Application by EPL 001 Ltd for Stonestreet Green Solar

The Examining Authority's written questions and requests for information (ExQ1) Issued on 10 January 2025

Written Representation prepared by Aldington & Bonnington Parish Council, 31 January 2025

Vegetation Removal Plan

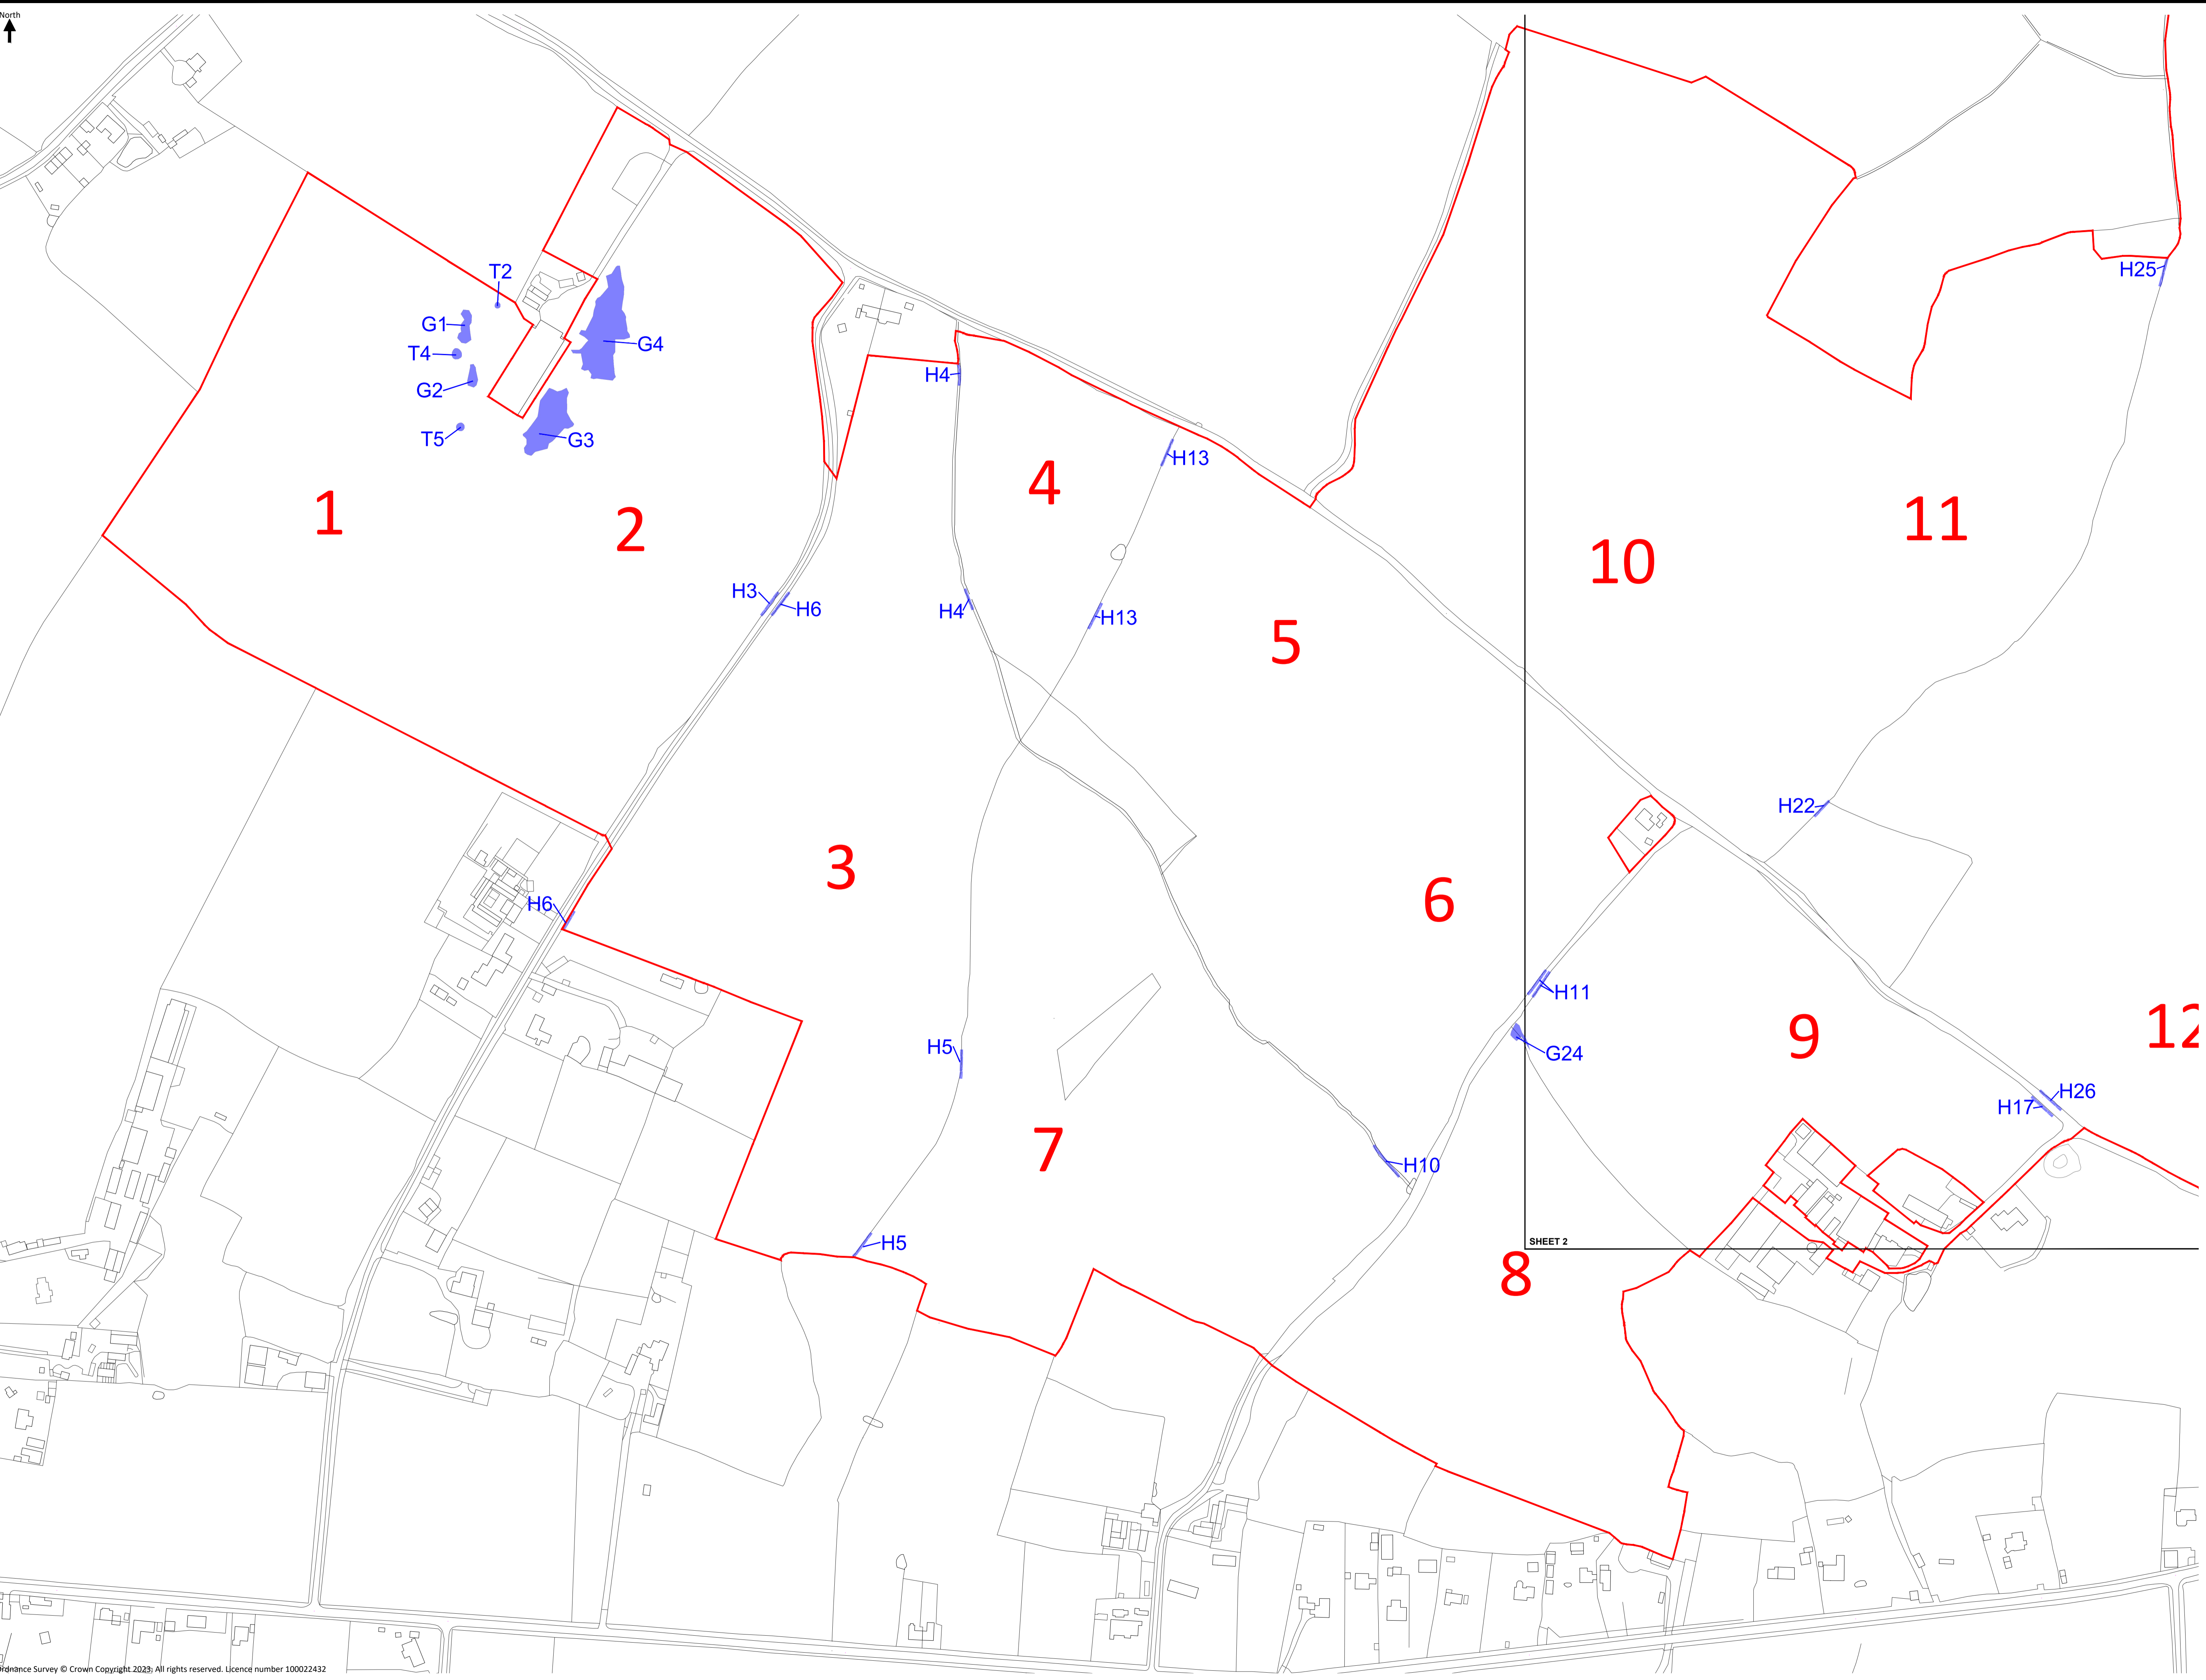
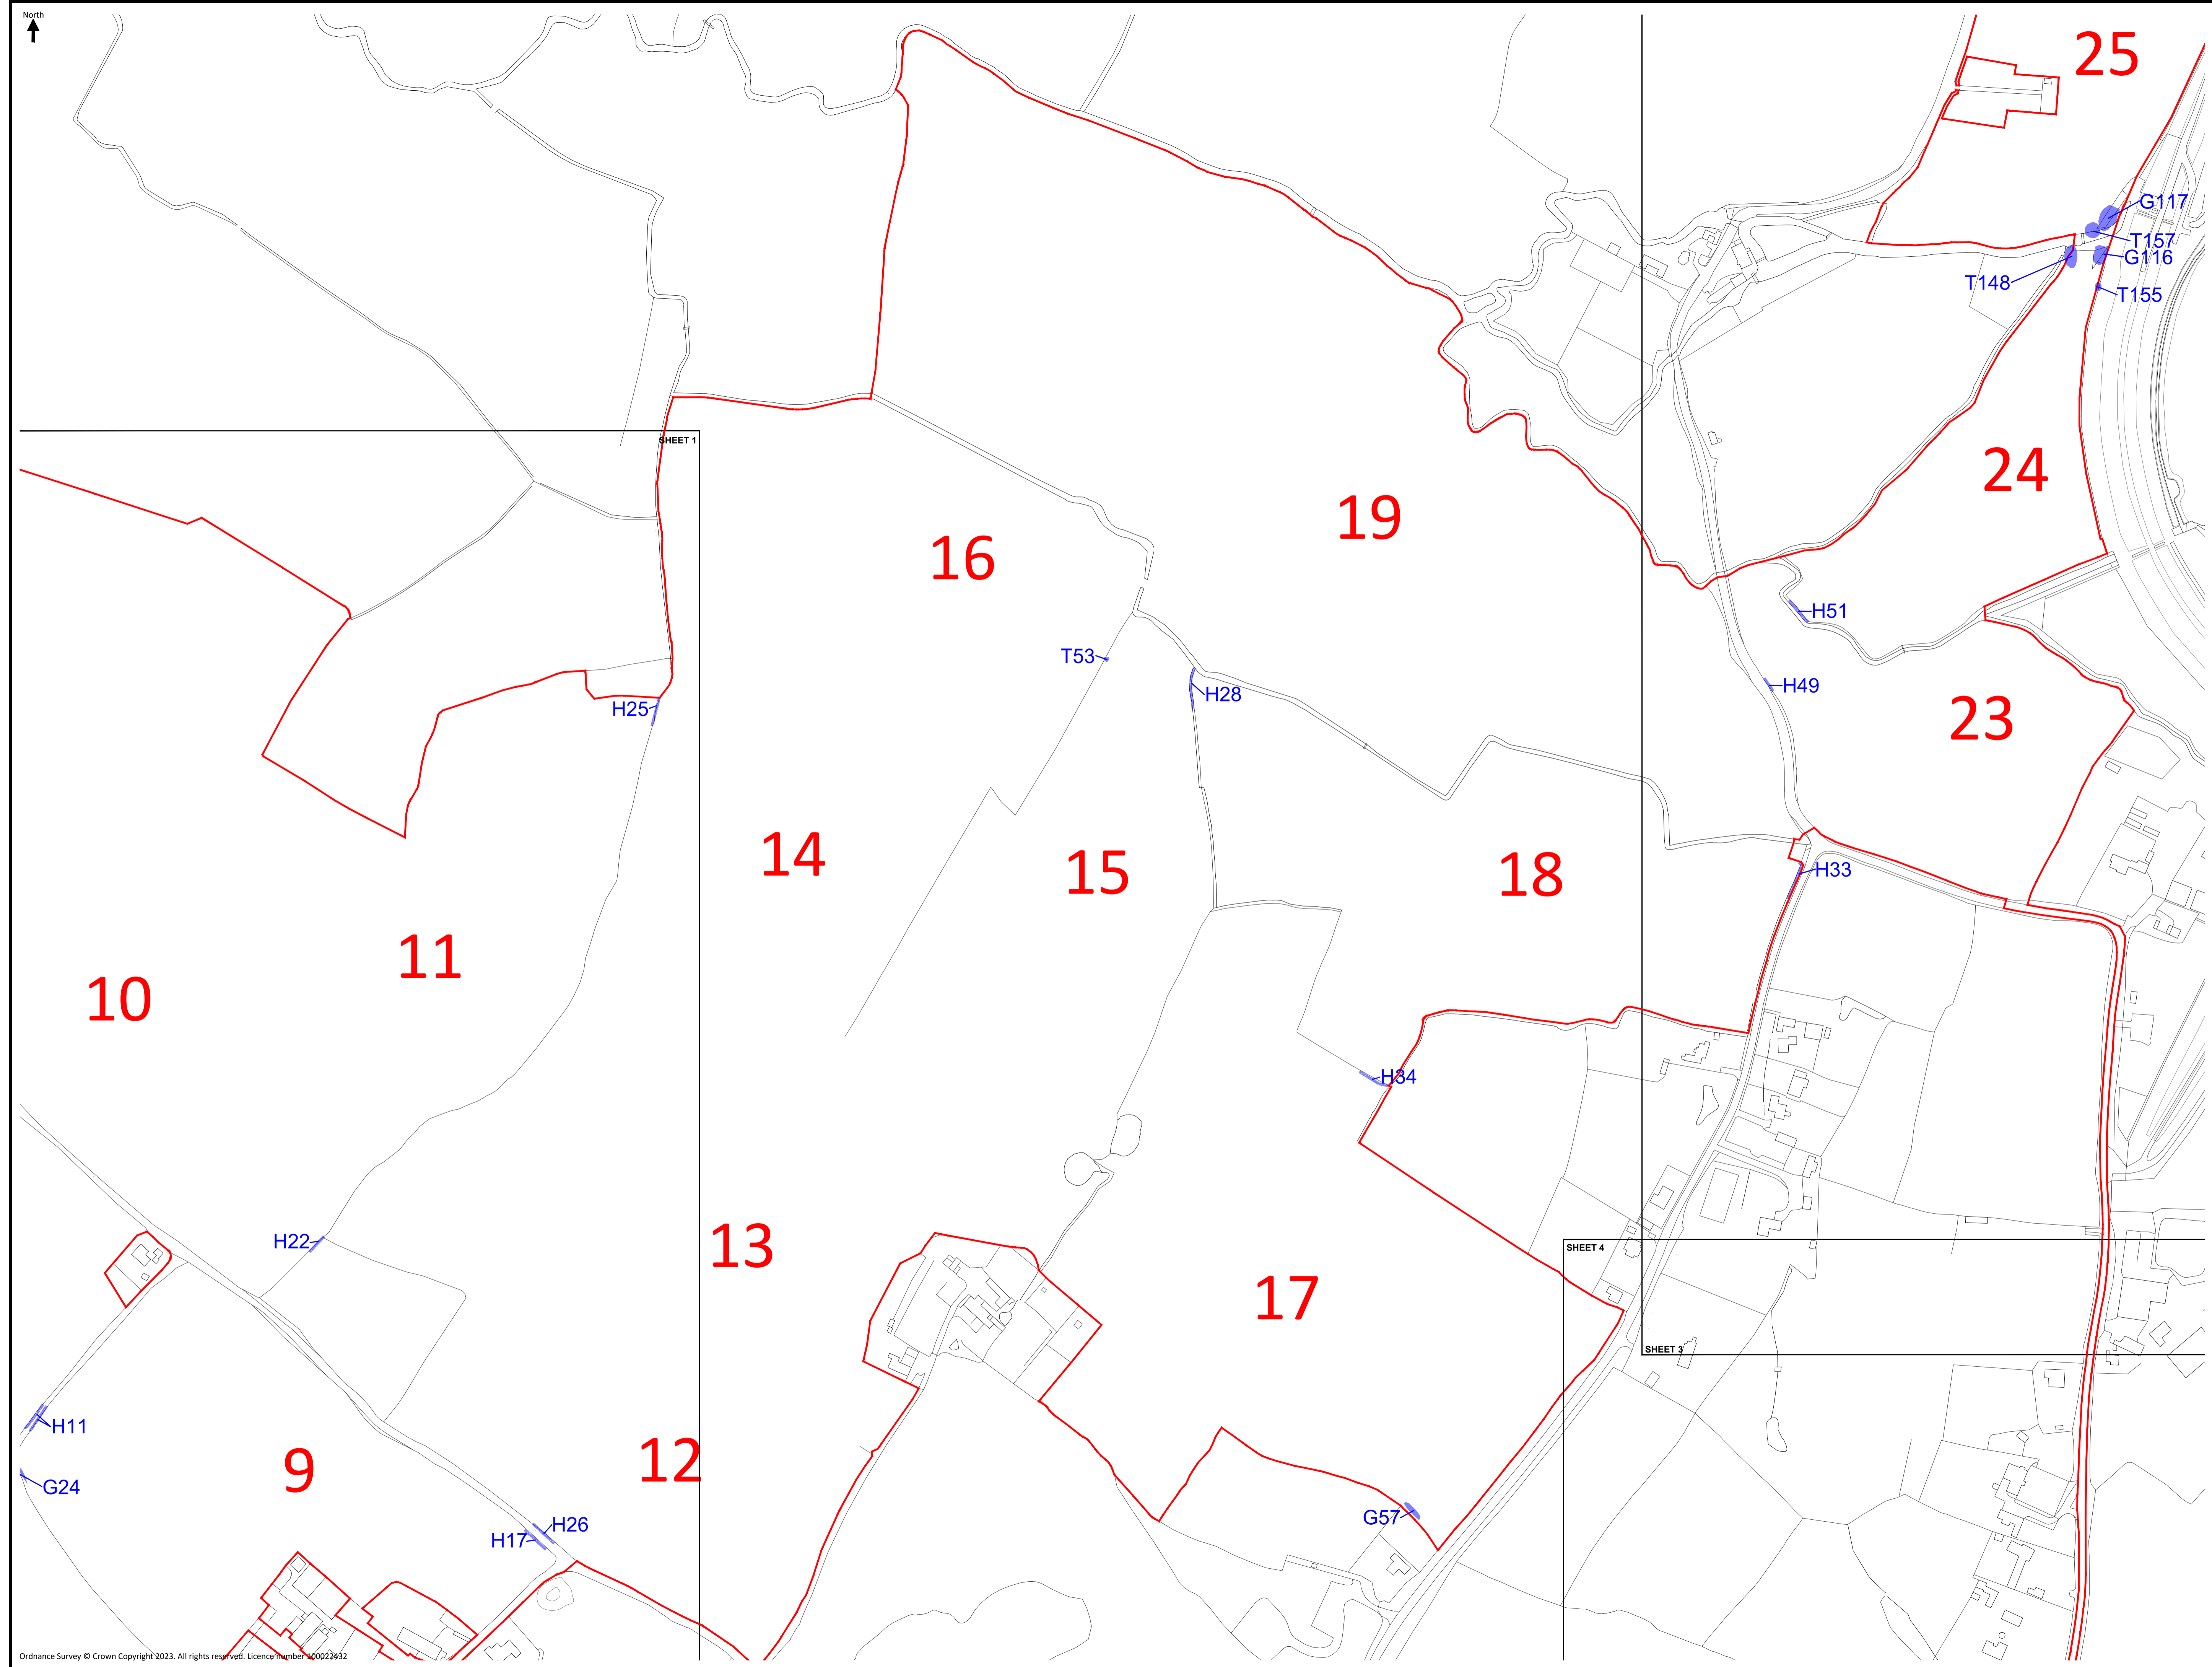
We strongly believe that this prior consent by the local planning authority should be required for the removal of trees and/or hedgerows. The Aldington and Bonnington Neighbourhood Plan (ABNP) is a legally binding document that forms part of the Local Development Plan, sitting alongside Ashford Borough Council's Local Plan. It represents the views of the community and should inform planning matters. Policy AB1 maps the green and blue infrastructure across the parish, with specific features identified as being important within this network. Some of these features fall within the proposed site footprint. As per Policy AB1, important species should be protected. We would request that any trees or hedgerows removed are replaced. We consider this appropriate and achievable. This would also align to ABNP Policy AB12 (C), which supports the retention of roadside and pathside hedges, trees and verges.

Our response under Q4.0.4 is relevant here. As part of the work on the ABNP, a hedgerow survey was undertaken and ABPC would be keen to be involved in discussions about important hedgerows. As above, some of these features fall within the proposed site footprint. As per Policy AB1, important species should be protected. We would request that any trees or hedgerows removed are replaced. We consider this appropriate and achievable.

We welcome this question and our response under Q4.0.4 is relevant here. There are a number of Tree Preservation Orders on trees in or adjacent to the site, including along some of the roads identified as main routes into/out of the site (Calleywell Lane and Station Road). In their response to ABPC's Deadline 1 submission, the Applicant states that "any damage resulting solely from construction activities will be rectified at the cost of the Applicant. Additionally, highway verges will be restored to their previous condition should temporary surfacing be laid across them to aid the passage of construction traffic." (Application Document Ref: 8.8, p. 151). No reference is made here to the removal of trees, including those with TPOs, which cannot simply be replaced.
